**From:** [Holly Duncan](#)  
**To:** [Dusty Pilkington](#)  
**Subject:** RE: VA-16-00001 Mostofi Variance  
**Date:** Tuesday, September 13, 2016 12:47:11 PM

**From:** Dusty Pilkington  
**Sent:** Tuesday, September 13, 2016 9:55 AM  
**To:** Holly Duncan; Lucas Huck  
**Subject:** VA-16-00001 Mostofi Variance

VA-16-00001

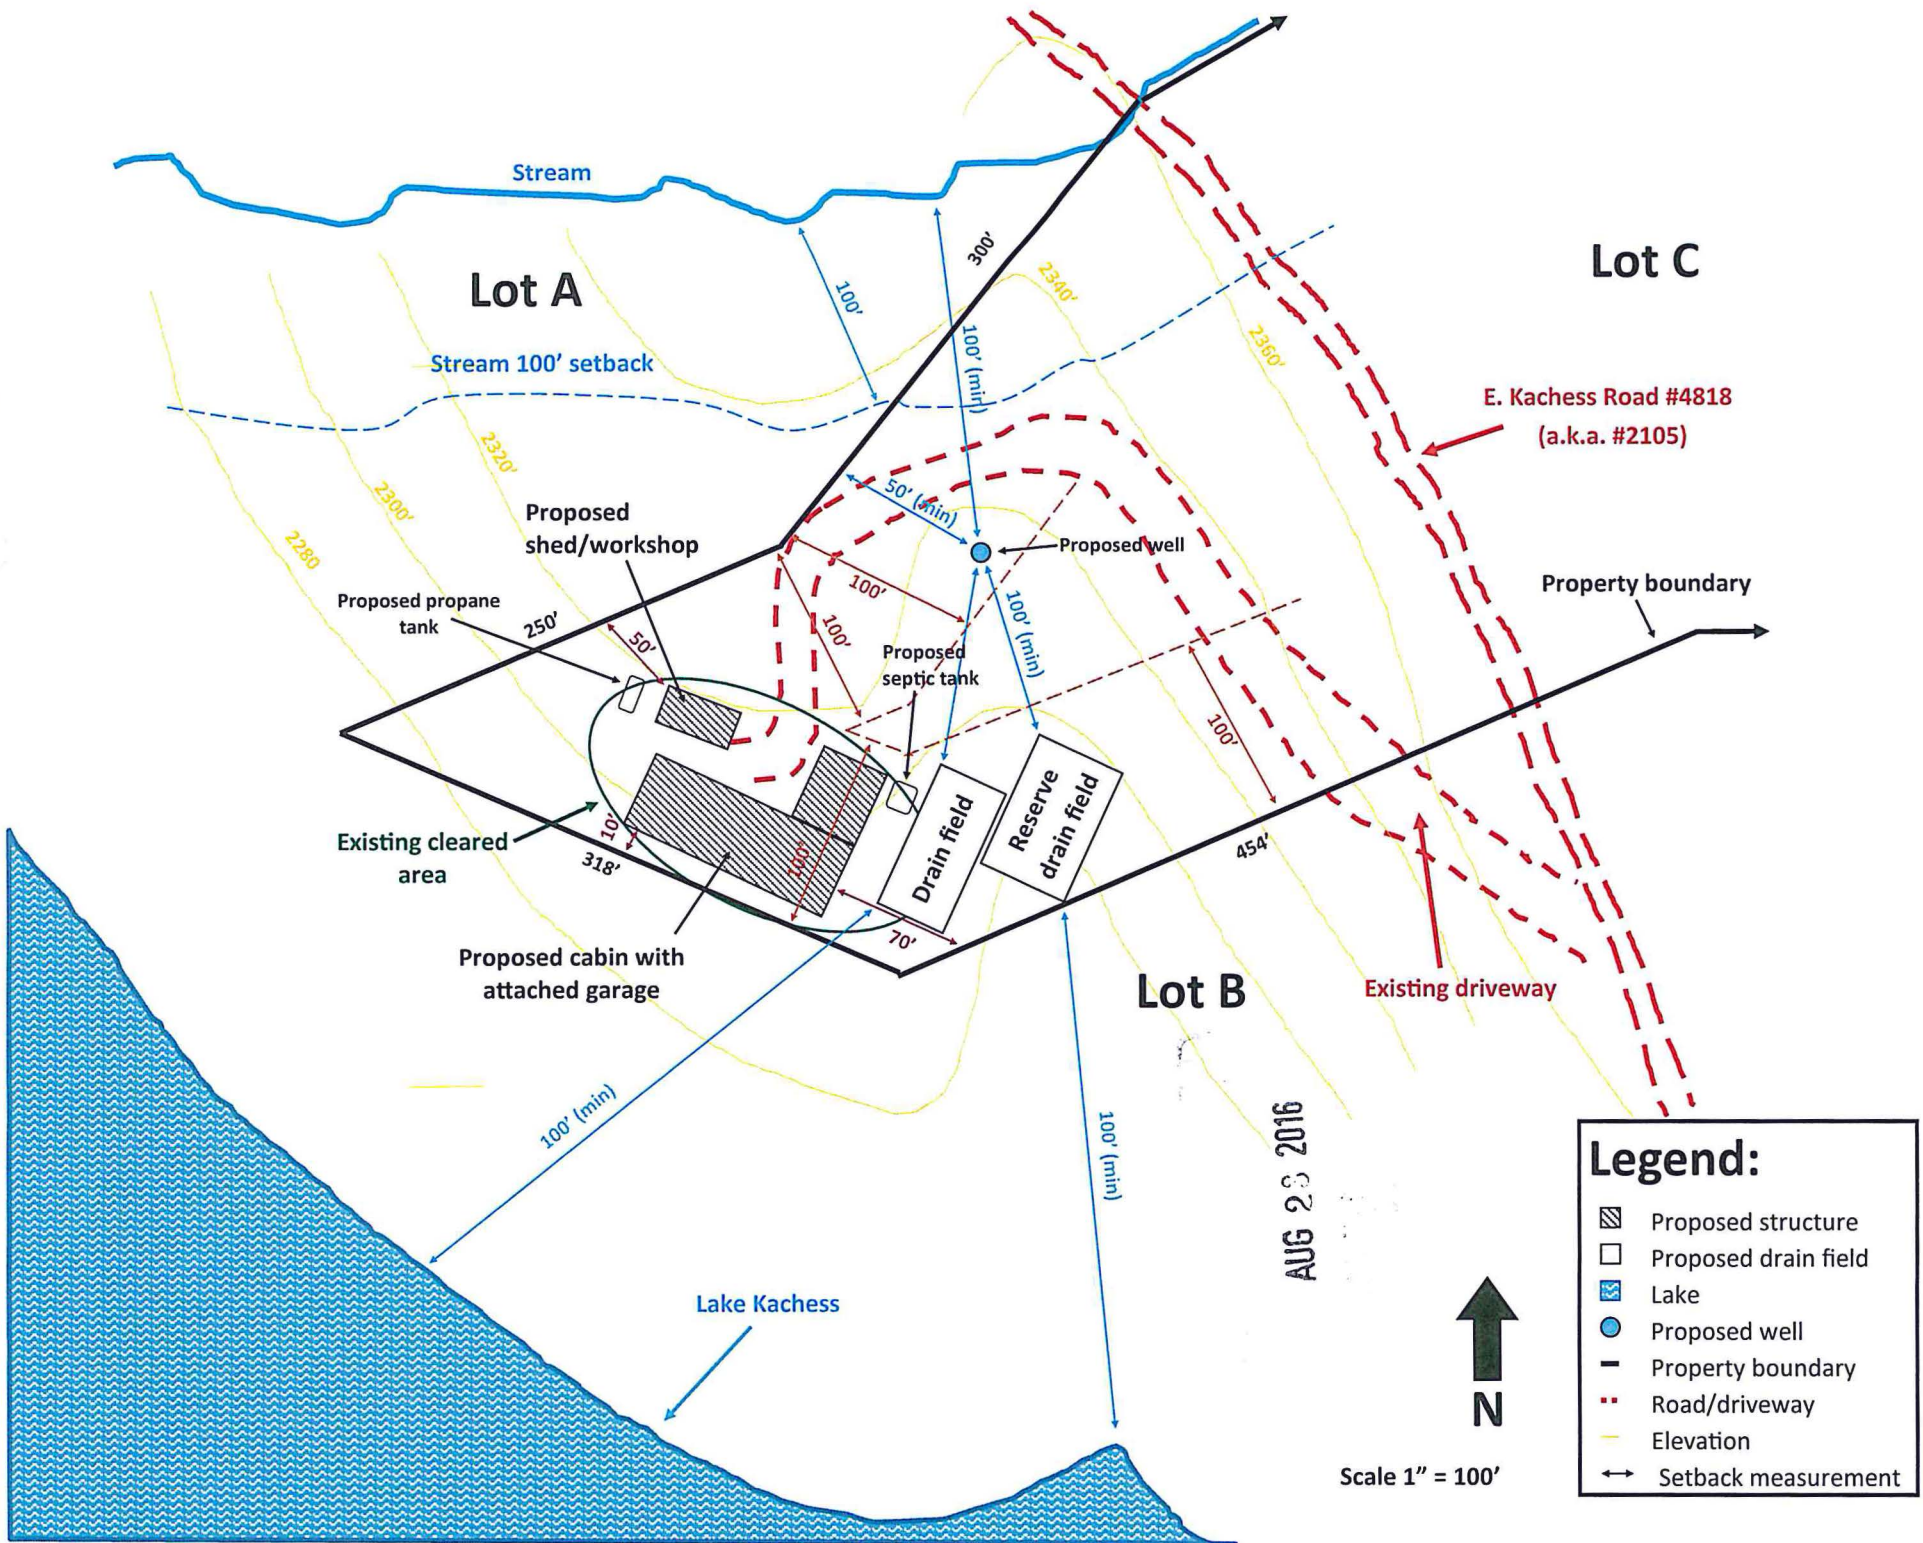
My only concern on this property is the grade. Getting a well drilling rig onto the property may be challenging and a drainfield cannot be installed on slopes greater than 30%.
